Ribble Valley Borough Council
Council Offices
Church Walk,
Clitheroe
Lancashire
BB7 2RA

Phone: 0300 123 6780
Email: developeras@lancashire.gov.uk
Your ref: 3/2025/0683
Our ref: 3/2025/0683/HDC/KW
Date: 12 June 2026

Location: Bowland Wild Boar Park Wardsley Road Chipping PR3 2HB
Proposal: Regularisation of the erection and use of five tipis as a wedding and events space in connection with Bowland Wild Boar Park and associated toilet block, storage building, catering tent and the creation of hardstanding for a temporary period until 1 November 2028.
Grid Ref: 365972 445114

Lancashire County Council acting as the Local Highway Authority (LHA) does not raise an objection regarding the proposed development and are of the opinion that the proposed development will not have a significant impact on highway safety or capacity in the immediate vicinity of the site subject to the following conditions being stated on any approval.

Annex D – Drawing A4011-H-01 Access Plan

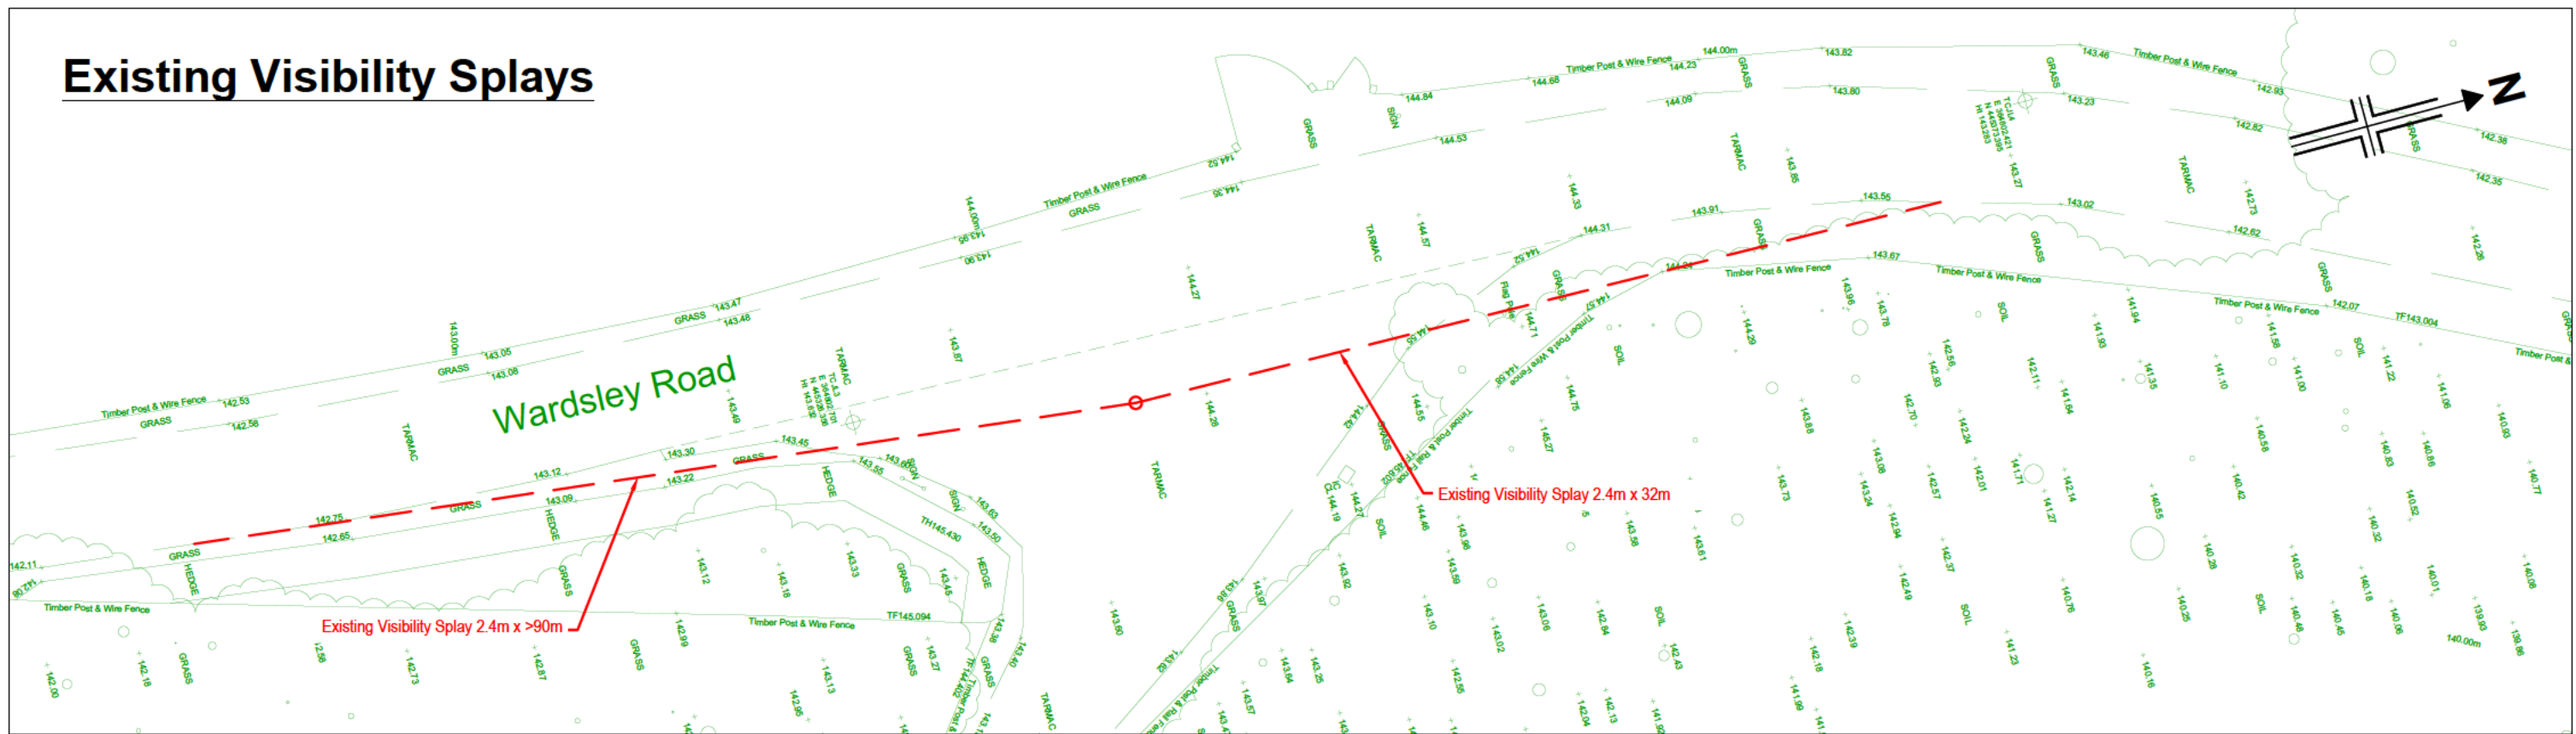
This shows that visibility to the south is achievable significantly beyond what is required based on the 85th percentile speed, although only 36m of the visibility splay is currently shown on the submitted plan.

To the north of the access, a visibility splay of 54m is shown on drawing A4011-H-01 Rev P1, representing a slight shortfall of 2m from the required 56m. To achieve the required visibility, a section of vegetation will need to be removed.

It is noted that vegetation surrounding the access has not been appropriately managed in recent years, resulting in a reduction in visibility over time. To ensure this does not continue, under a Section 278 agreement of the Highways Act, any land within the visibility splay envelope must be dedicated as highway maintainable at public expense. As part of this process, the LHA would seek the provision of a hardstanding area to the north of the access, which is approximately 4m in width and 30m in length, to reduce the long-term need for vegetation maintenance. The existing fence line will also need to be set back accordingly.

Mitigation currently required as part of the proposal includes a package of Section 278 highway works and associated measures necessary to make the development acceptable in highway terms. These works must include the provision of a hardstanding area to the North of the access, which shall cover the visibility splay envelope that currently falls within the applicant's ownership. Add land dedication

8. Within 3 months of this permission, a scheme for the highway improvement and land dedication, including hardstanding provisions to the north of the access, associated with the required visibility splay has been submitted to, and approved by, the Local Planning Authority in consultation with the Highway Authority as part of a section 278 agreement, under the Highways Act 1980. Implemented within an agreed timescale.
Reason: In order to satisfy the Local Planning Authority and Highway Authority that the final details of the highway scheme/works are acceptable before work commences on site and to enable all construction traffic to enter and leave the premises in a safe manner without causing a hazard to other road users.

9. A visibility splay 2.4 metres back from the centre line of the access and extending 49m to the South and 54m metres to the North on the nearside carriageway edge in both directions, as shown on the approved plans. Nothing shall be erected, retained, planted and / or allowed to grow at or above a height of 0.9 metres above the nearside carriageway level which would obstruct the visibility splay. The visibility splay shall be maintained free of obstruction at all times thereafter for the lifetime of the development.
Reason: To ensure adequate inter-visibility between highway users at the street junction or site access, in the interests of highway safety.
